KIRKLEES METROPOLITAN COUNCIL INVESTMENT & REGENERATION SERVICE

DELEGATED DECISION TO DETERMINE PLANNING APPLICATIONS

Reference No:	2022/62/91044/W
Site Address:	15, Cleveland Road, Edgerton, Huddersfield, HD1 4PP
Description:	Erection of single storey rear extension and alterations (within a Conservation Area)
Recommending Officer:	Luke Walstow

DECISION – Conditional Full Permission

Scale: 1/50 & 1/100	Drawing Number 2021/064/03	Rev. A	Date Drawn March 2022	Drawn By Andrew Smith
------------------------	-------------------------------	-----------	--------------------------	--------------------------

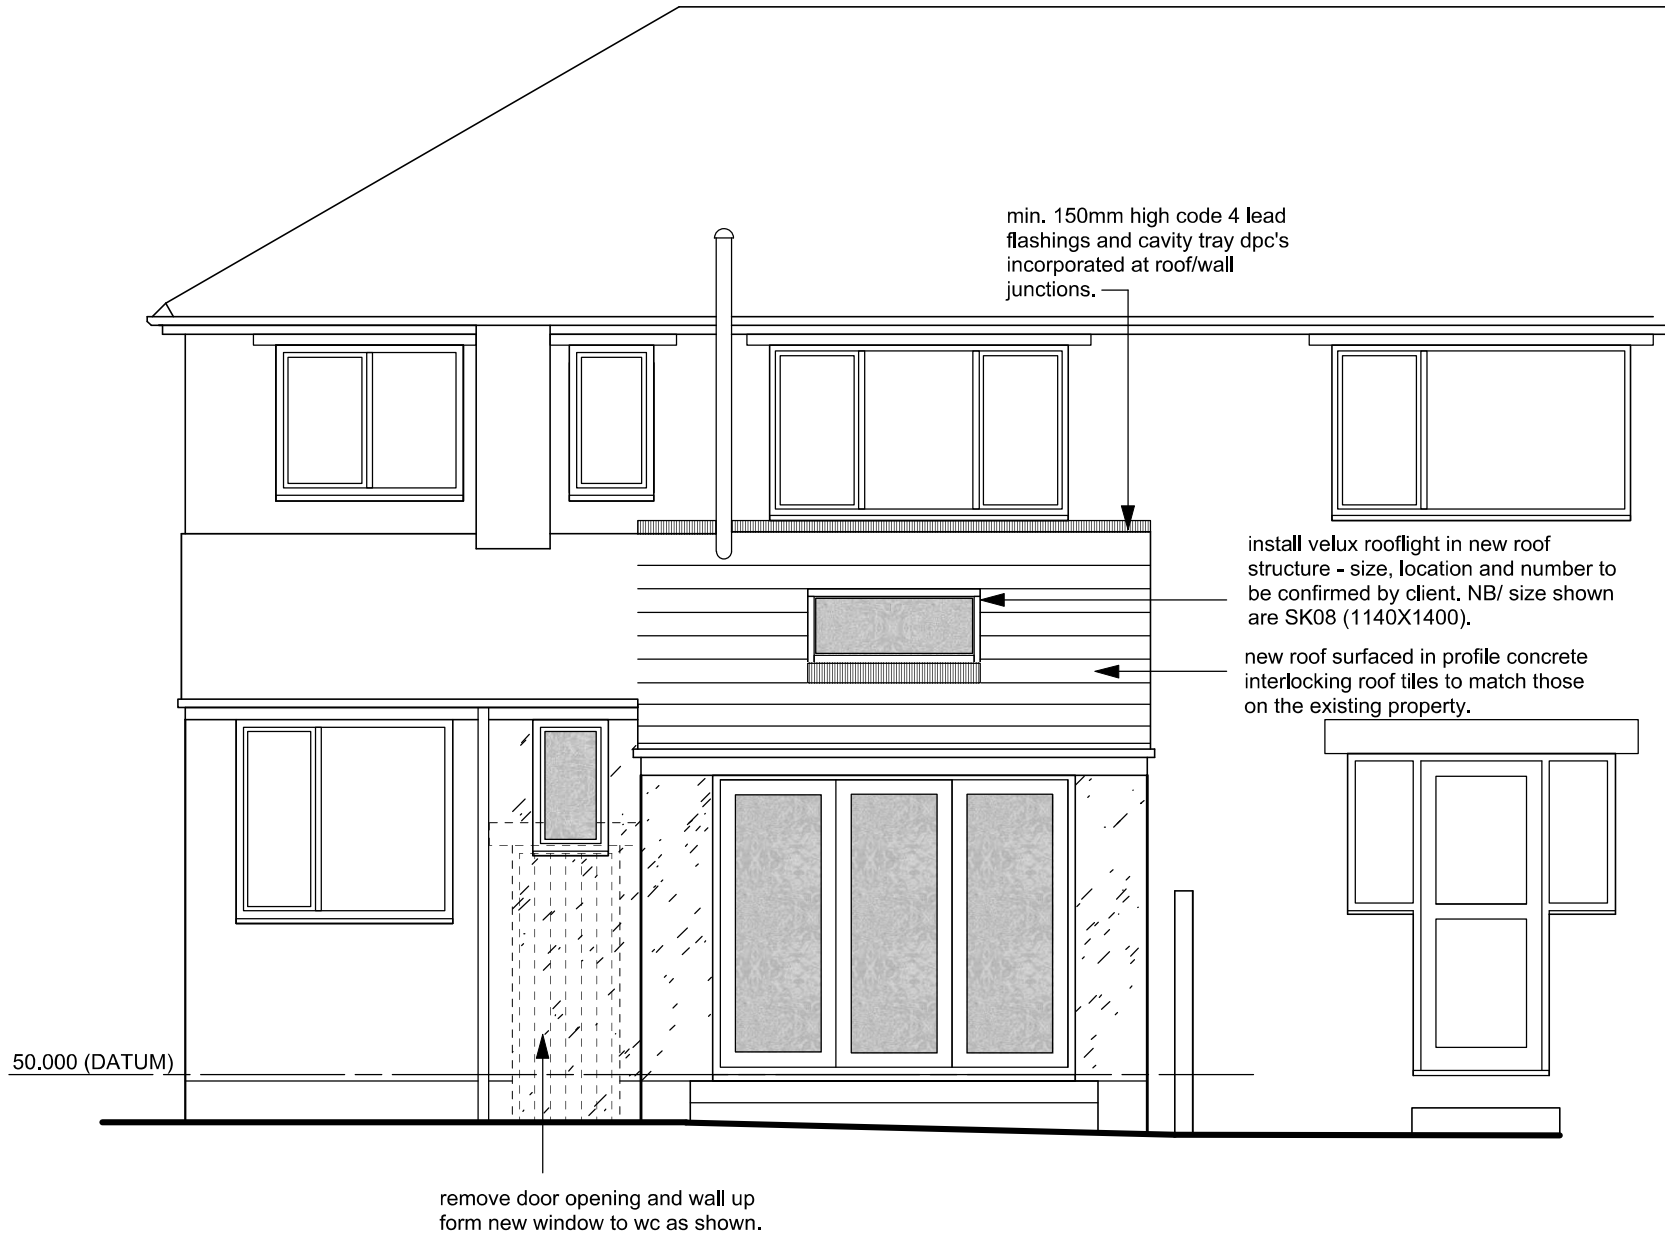
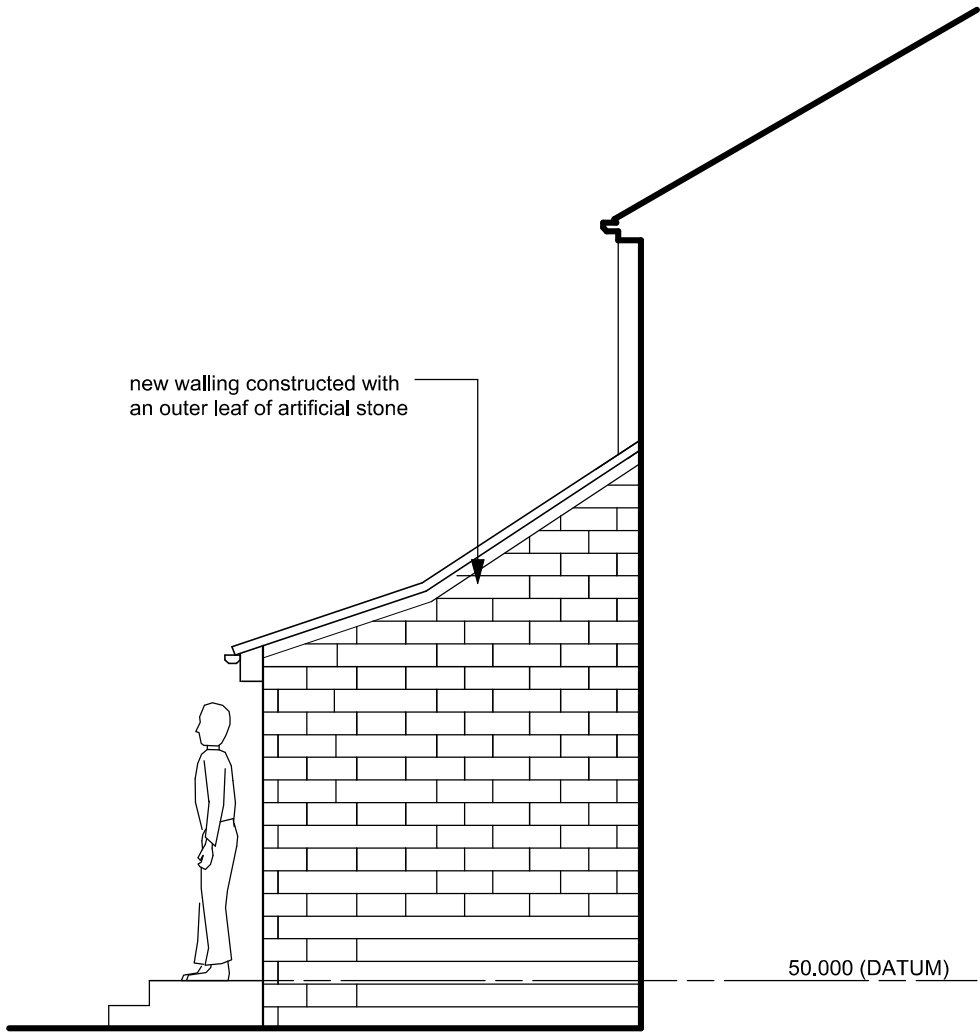
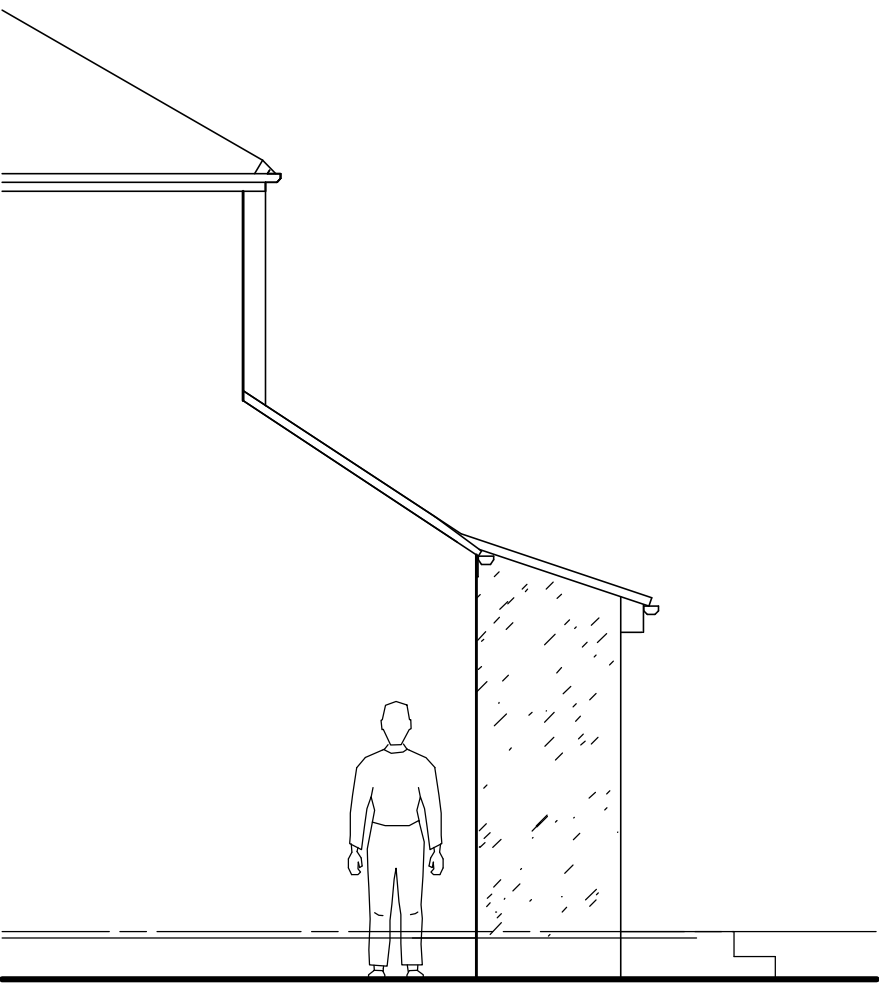
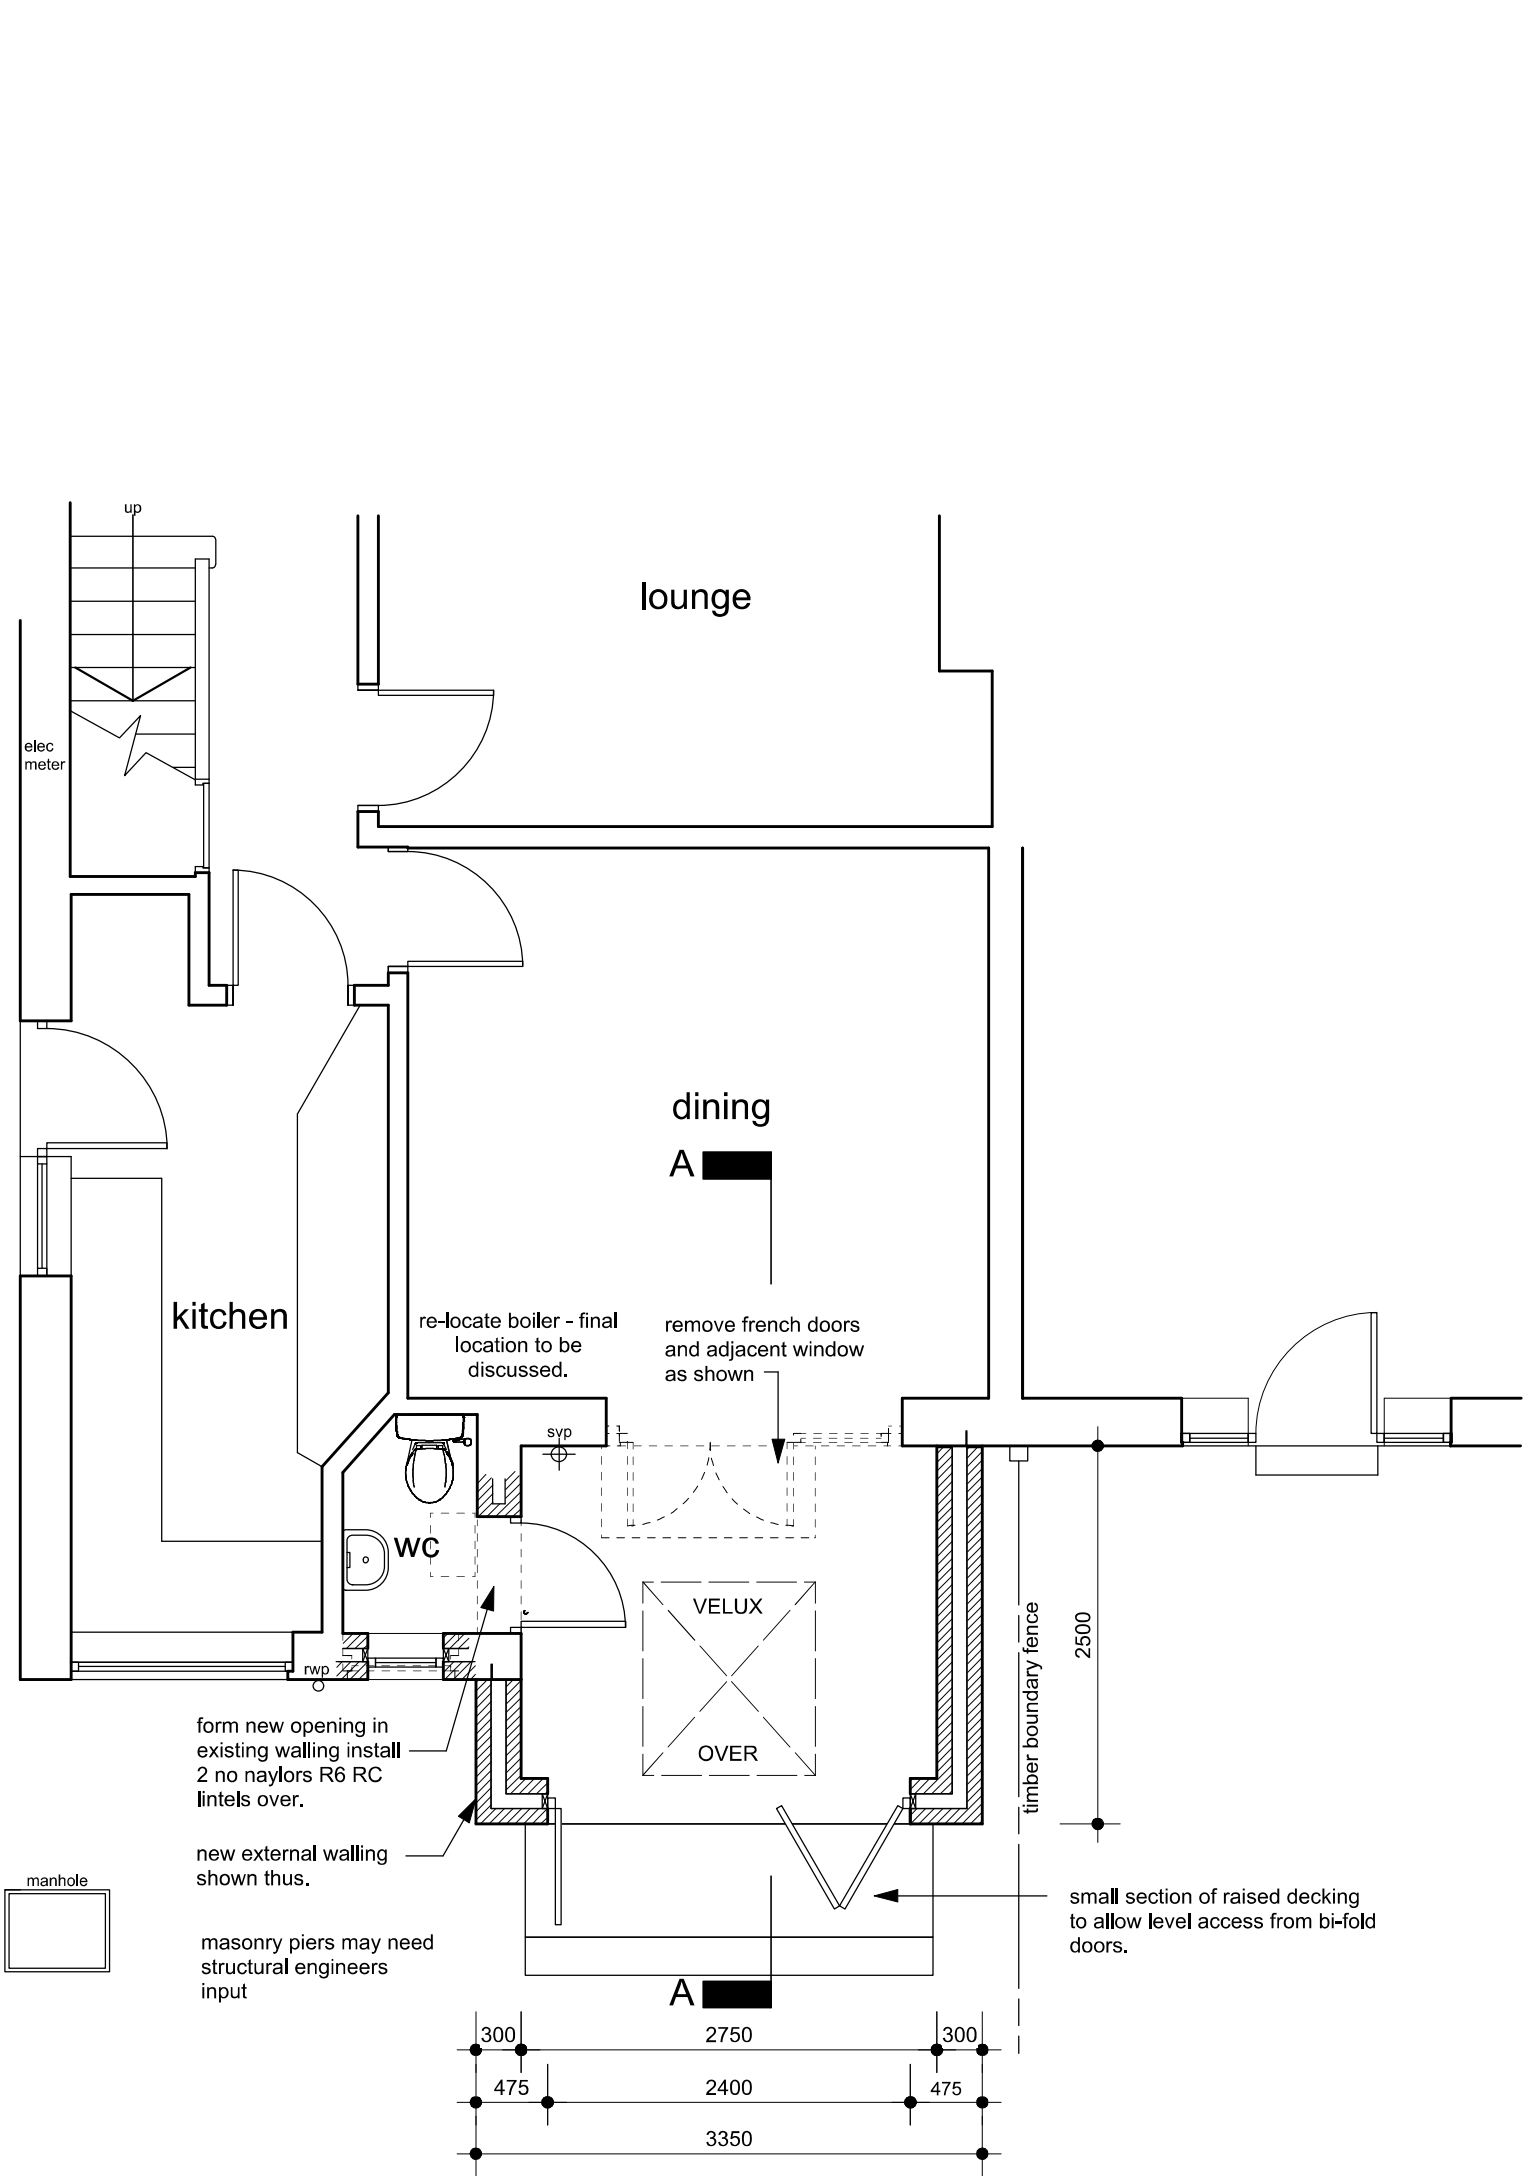
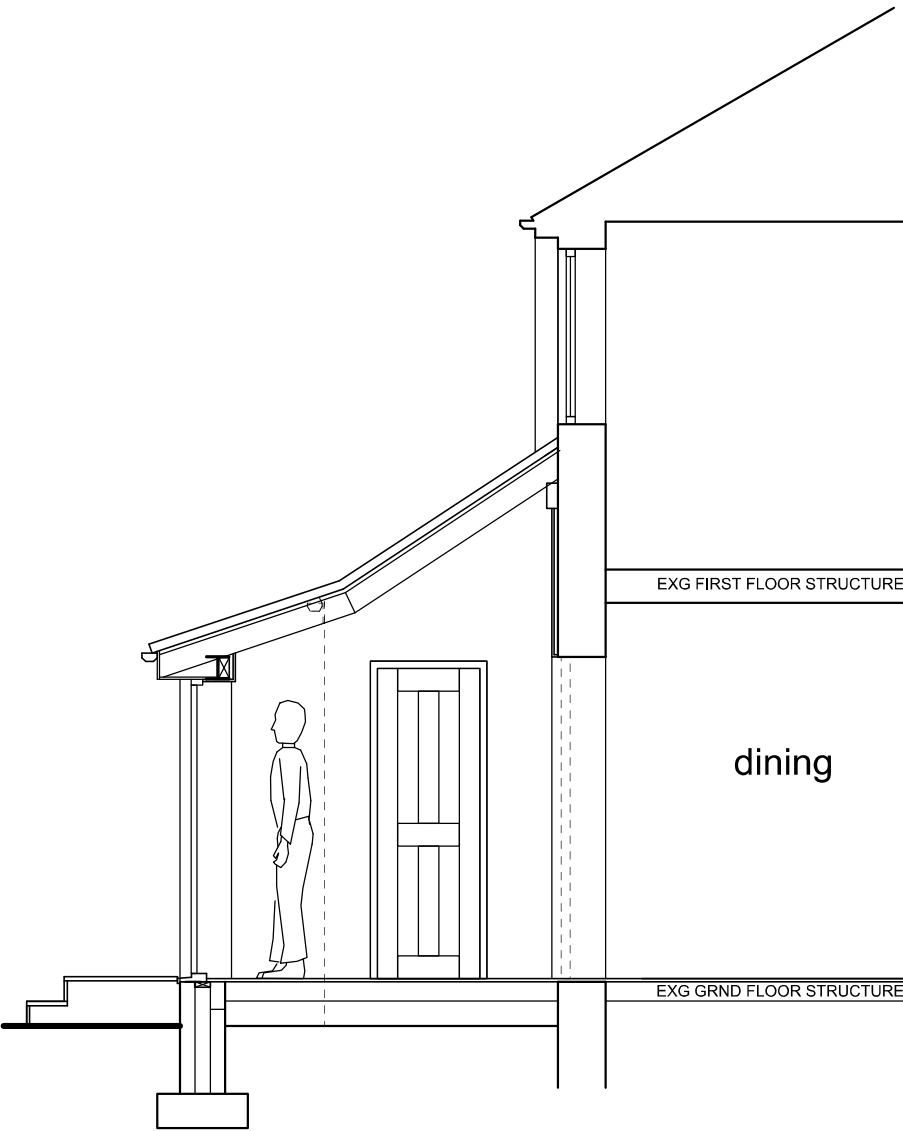
- 1) Reduced in depth from 3.0 to 2.5m.
- 1) Height of roof reduced slightly both intersection with existing house and at eaves.
- 2) Roof pitch altered to reflect the existing outrigger.

In this case the development would satisfy all these points, except it would be less than 1m from the property boundary.

The proposal would project 2.5m beyond the rear wall of the main dwelling and reach a maximum height of 4 metres, where the roof adjoins the main dwelling. There will be no window installed within the proposed extension that can overlook into the neighbouring property at no. 13.

To comply with principle 5 of the House Extensions SPD, a 45 degree rule is used to assess the impact of an extension on natural light for neighbouring properties. A line is drawn from the midpoint in the nearest habitable room window of the adjacent property (no. 13), at an angle of 45°, across the proposed extension. The extent to which the line infringes upon the proposed extension will indicate the levels of light that may be lost to the neighbouring property. After following the guidance, it is found that the proposed extension narrowly fails to comply with the angle of 45°, it is close to 50°. The orientation of the extension to no. 13 is that it is to the south west which means some sunlight in the early afternoon would be lost to the neighbouring property as a result of the development. Some mitigation to this is that there is mature boundary treatment between the properties at this time which forms some shading, especially the outdoor space. There is also a more harmful scenario which would be the application of permitted development rights which would allow an extension of 3m in rear projection, of the same ridge height and to be erected on the boundary. This is a realistic fallback position that weighs in favour of the current proposal for a more modest scheme. This reduced scheme is the subject of amended plans. The affected windows – which appear to serve a habitable room, would still have an open outlook and receive sunlight over a significant period of the day, as would the expansive patio area. Taking all this into account, the development is considered acceptable in this specific case.

3. The artificial stone proposed for the side elevation of the extension hereby approved shall harmonise with the colour of natural stone walling used in the front elevation of the host dwelling. The colour of the spray render finish to the other external walls of the development hereby approved shall harmonise with the colour of the pebbledashed render finish to the rear elevation of the host dwelling.
